**Re: Horsley Drive Business Park
 Fairfield Council Stormwater Queries**

Further to the recent State Significant Planning Submission at the above project address, we hereby provide the following response to comments from Fairfield City Council contained in a memo titled “*Comments on Horsley Drive Business Park – Costin Roe Consulting Civil Engineering Report by Catchment Management Branch*”, dated 18 September 2012.

**BASIN 2 OUTLET DETAIL**  
1:20

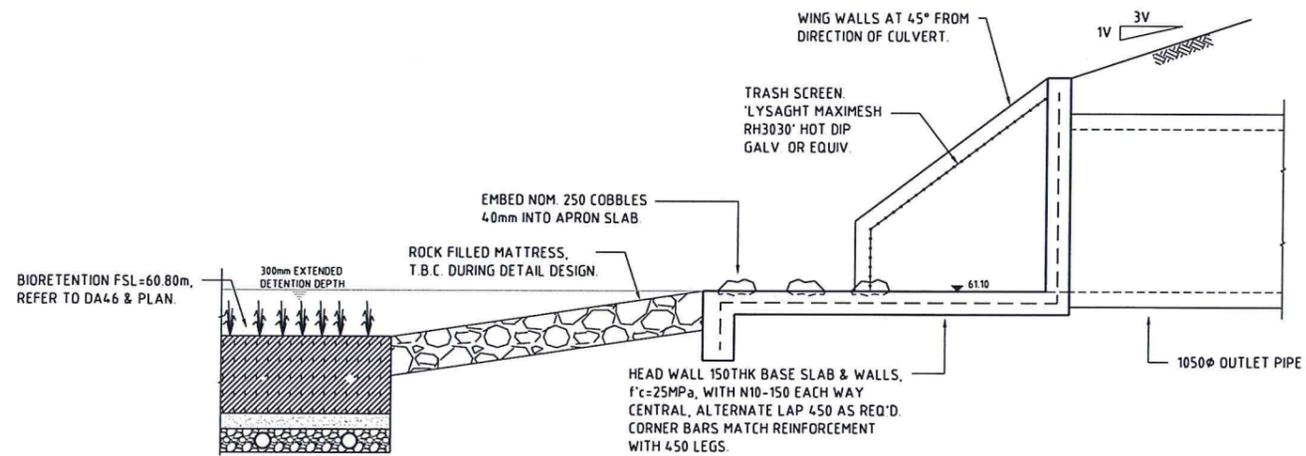
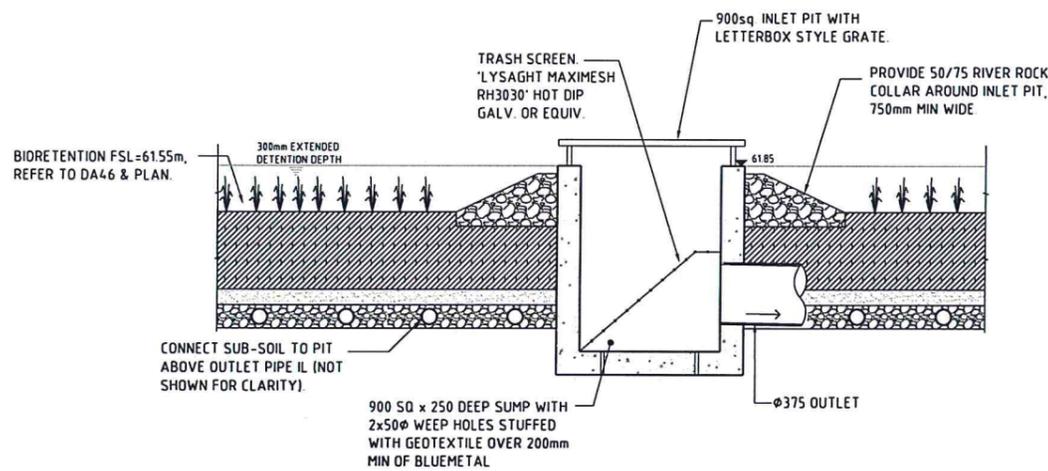
5.6	16	<p><i>Details need to be provided with respect to the outlet configuration of both of the basins to ensure they are in compliance with Councils OSD policy requirements.</i></p> <p><u>Response</u></p> <p>Please refer to new drawing DA47 for typical outlet configuration of the basins. Concept details shown will be further developed during detail design phase of the project.</p> <p>Refer drawing DA47.</p>

EXISTING CATCHMENT SCHEDULE

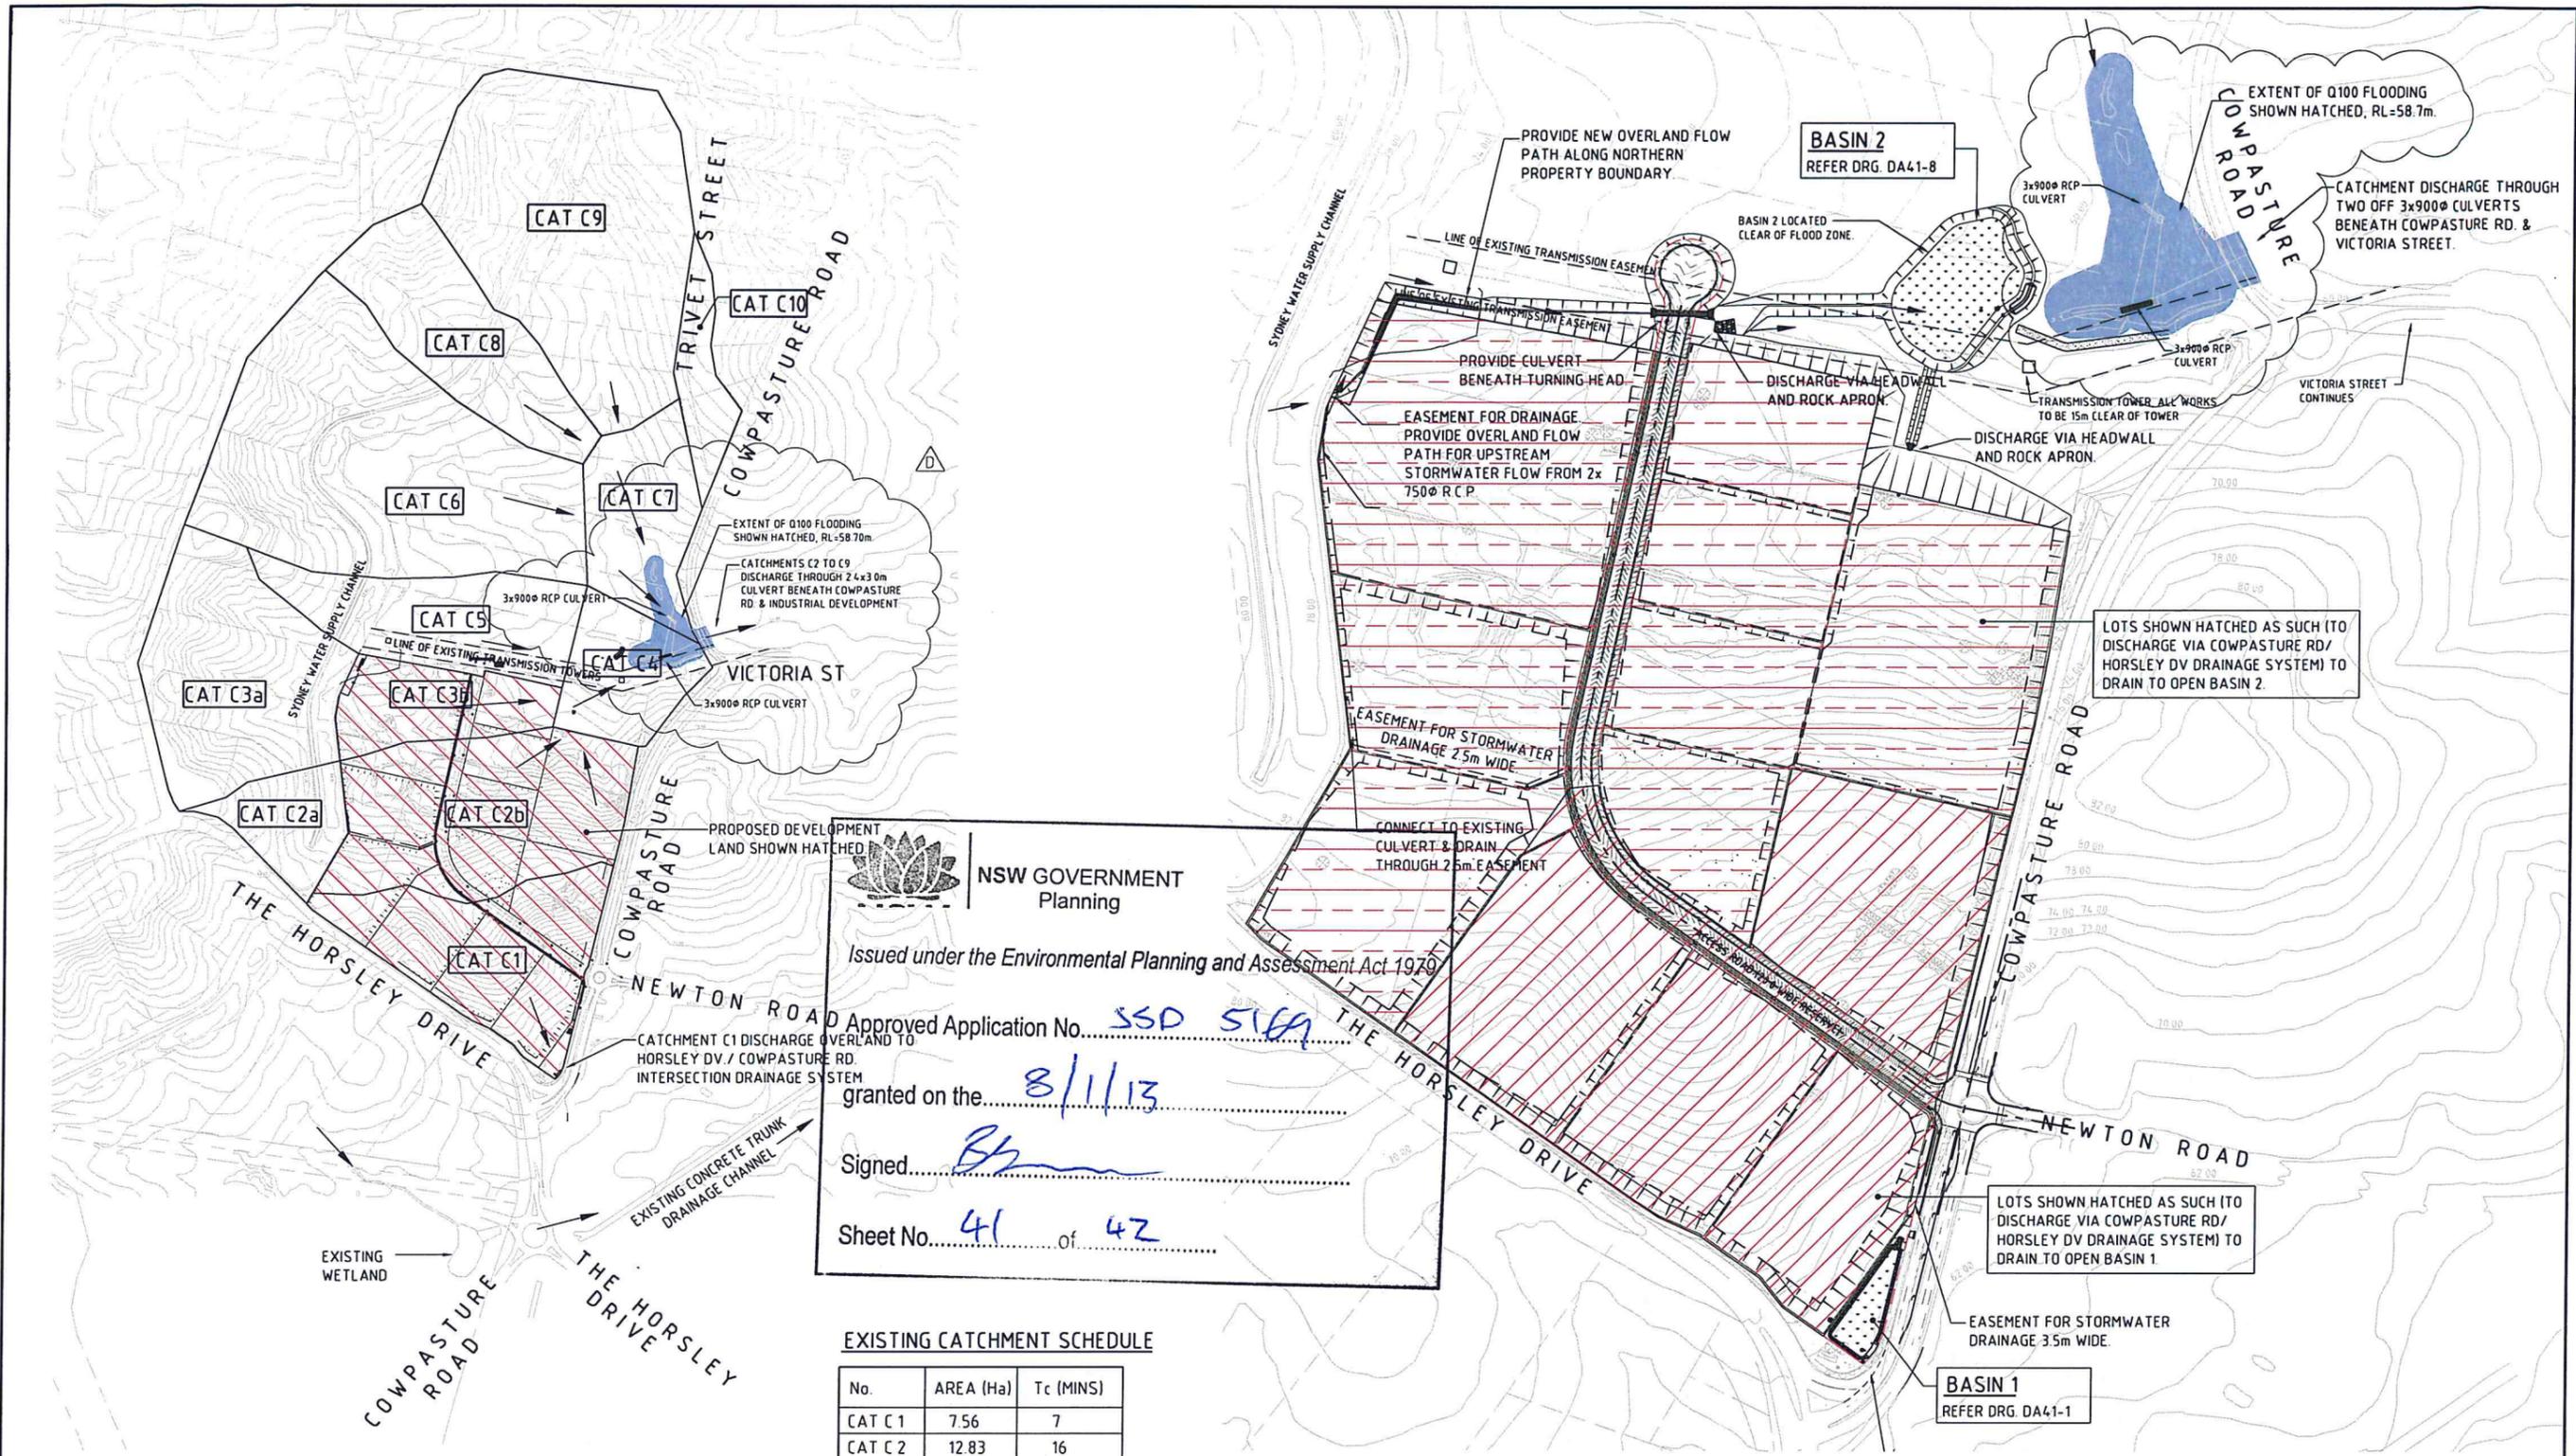
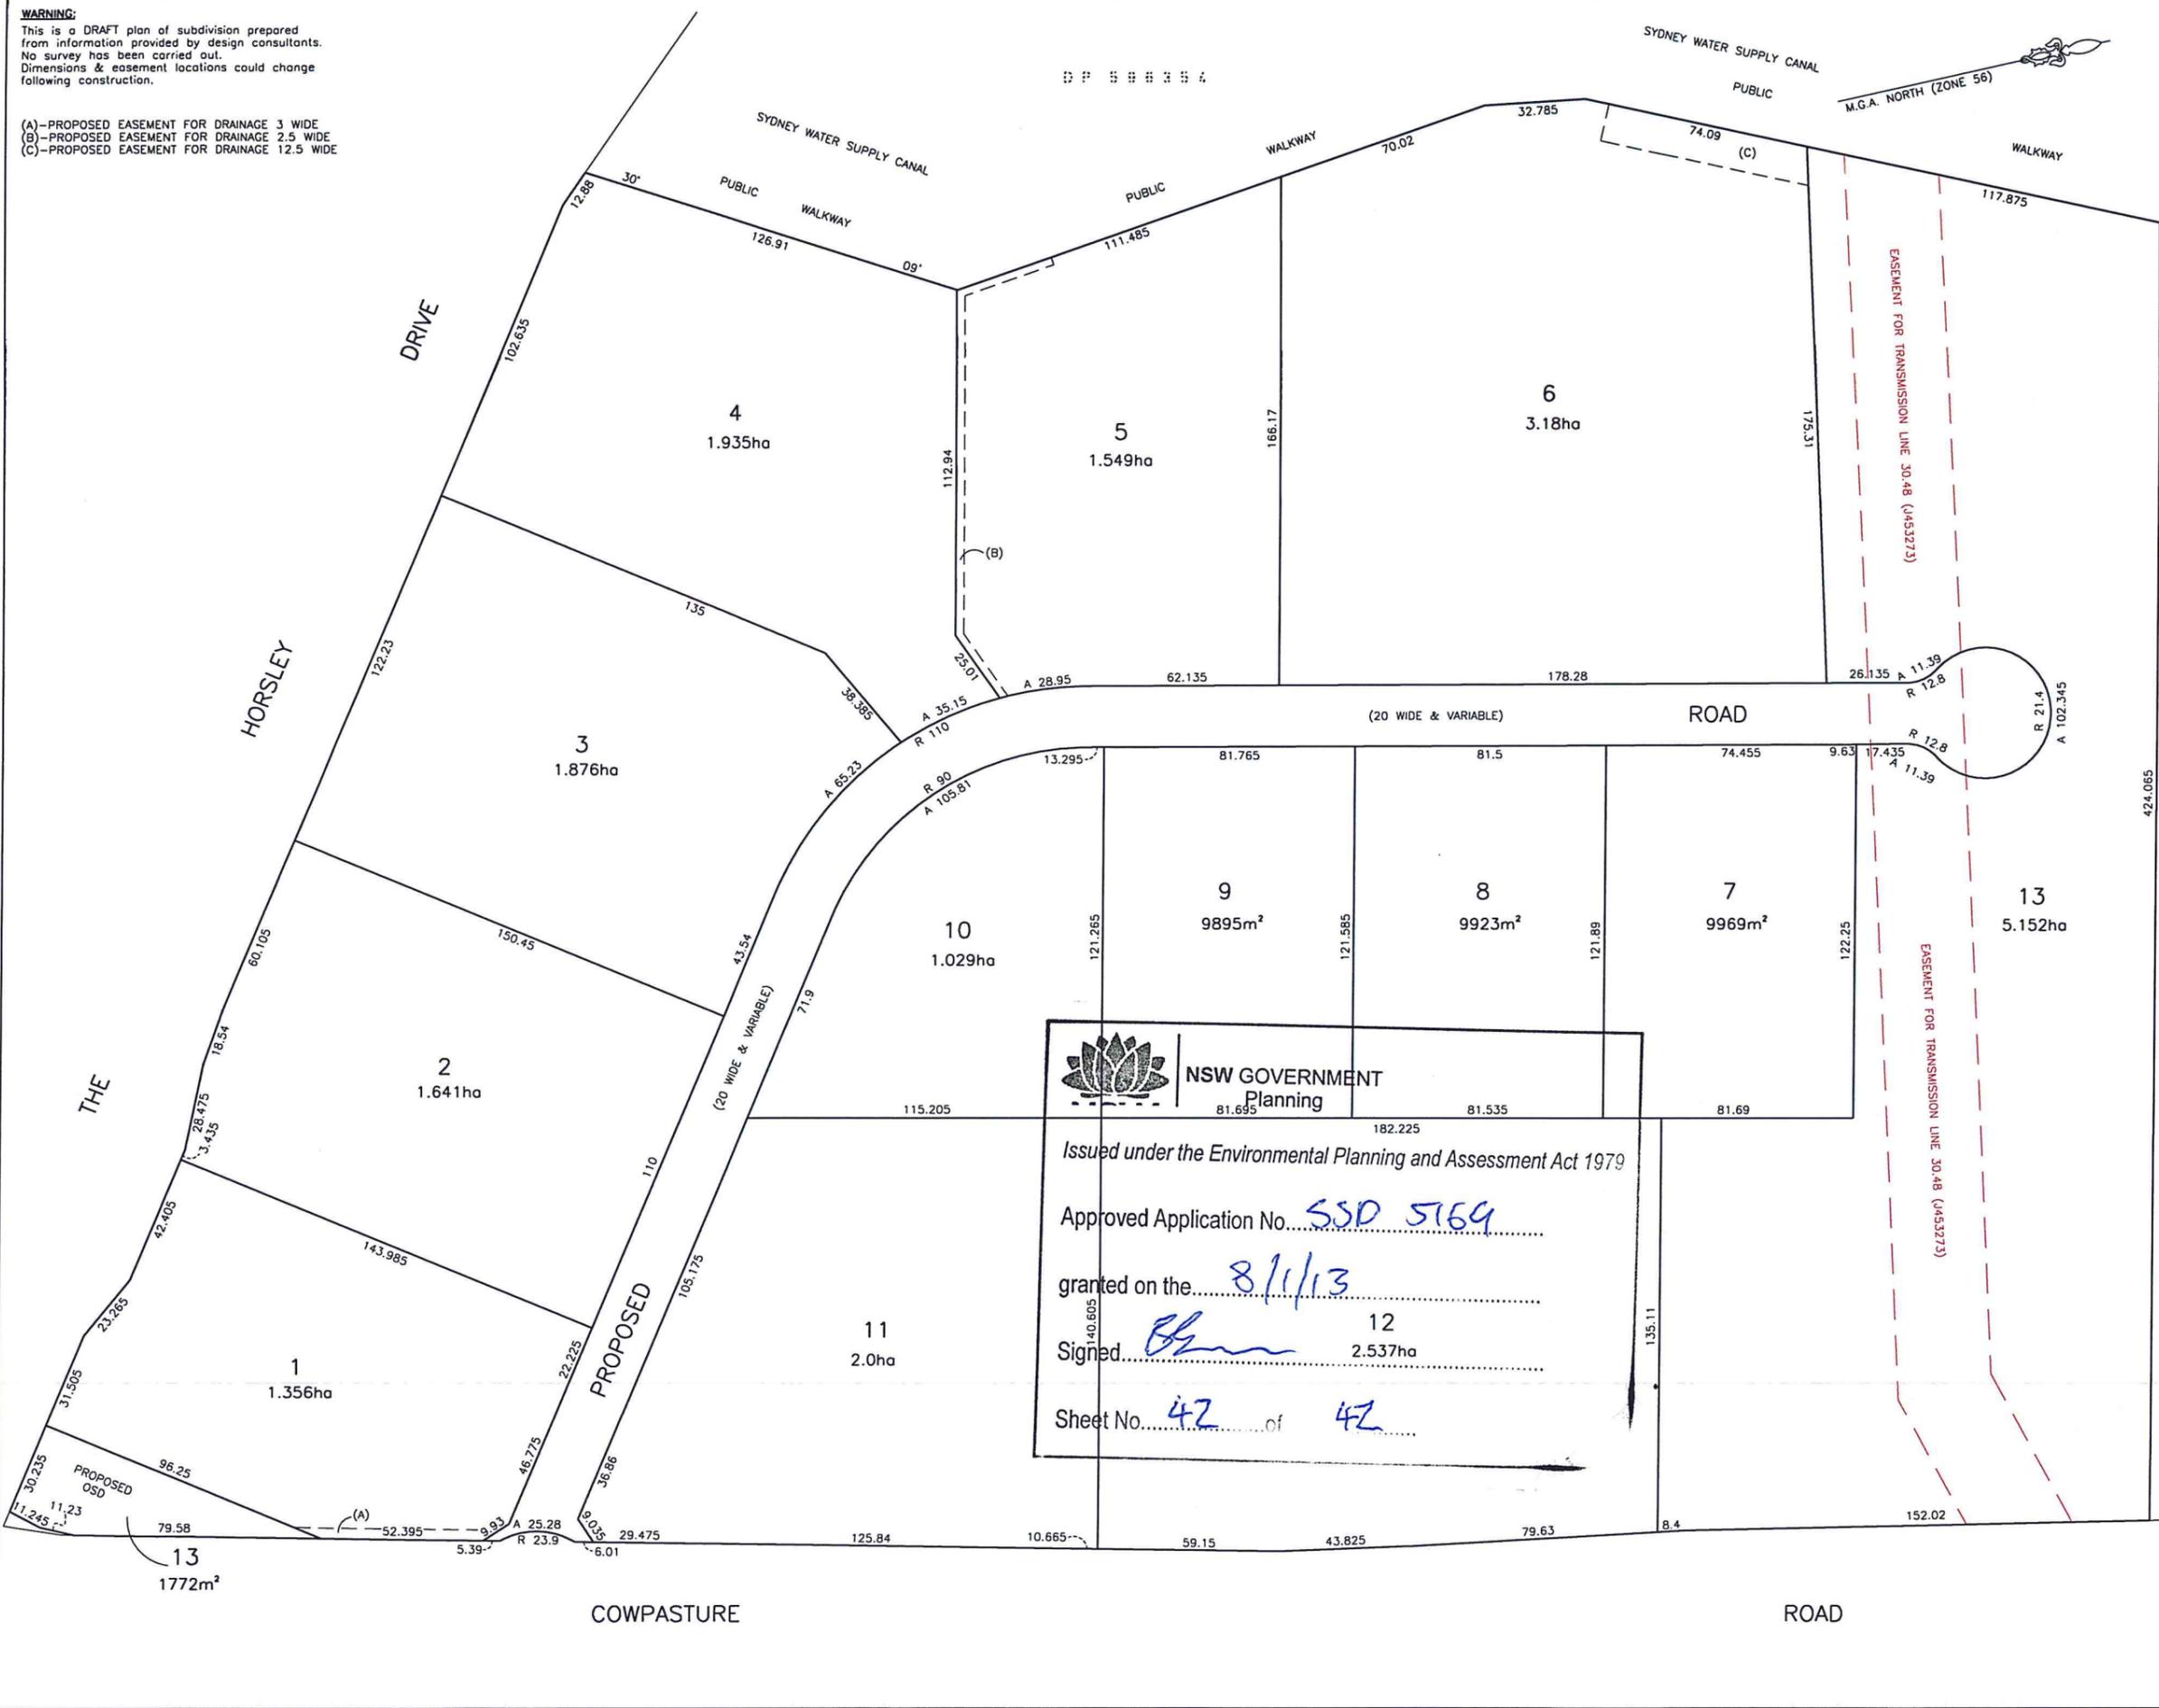
5.3.1	12	<p><i>Catchment areas stated within this section of the report do not correlate to those presented on drawing Co11492.00-DA70. Need to confirm which catchment areas are correct and make necessary changes.</i></p> <p><u>Response</u></p> <p>Catchment areas have been checked and minor differences noted have been adjusted in the report and on plan. Refer to updated report, Revision B and revised drawing DA70.</p>

5.5	14	<p><i>Total catchment of 87.9ha should be smaller as it should not include catchment C1 of 7.56 ha.</i></p> <p><u>Response</u></p> <p>The total catchment has been reviewed and we confirm it is 83.6Ha (this now includes 2.06Ha from Trivet St which was requested by Fairfield Council).</p> <p>Refer to updated report Revision B and drawing DA70.</p>
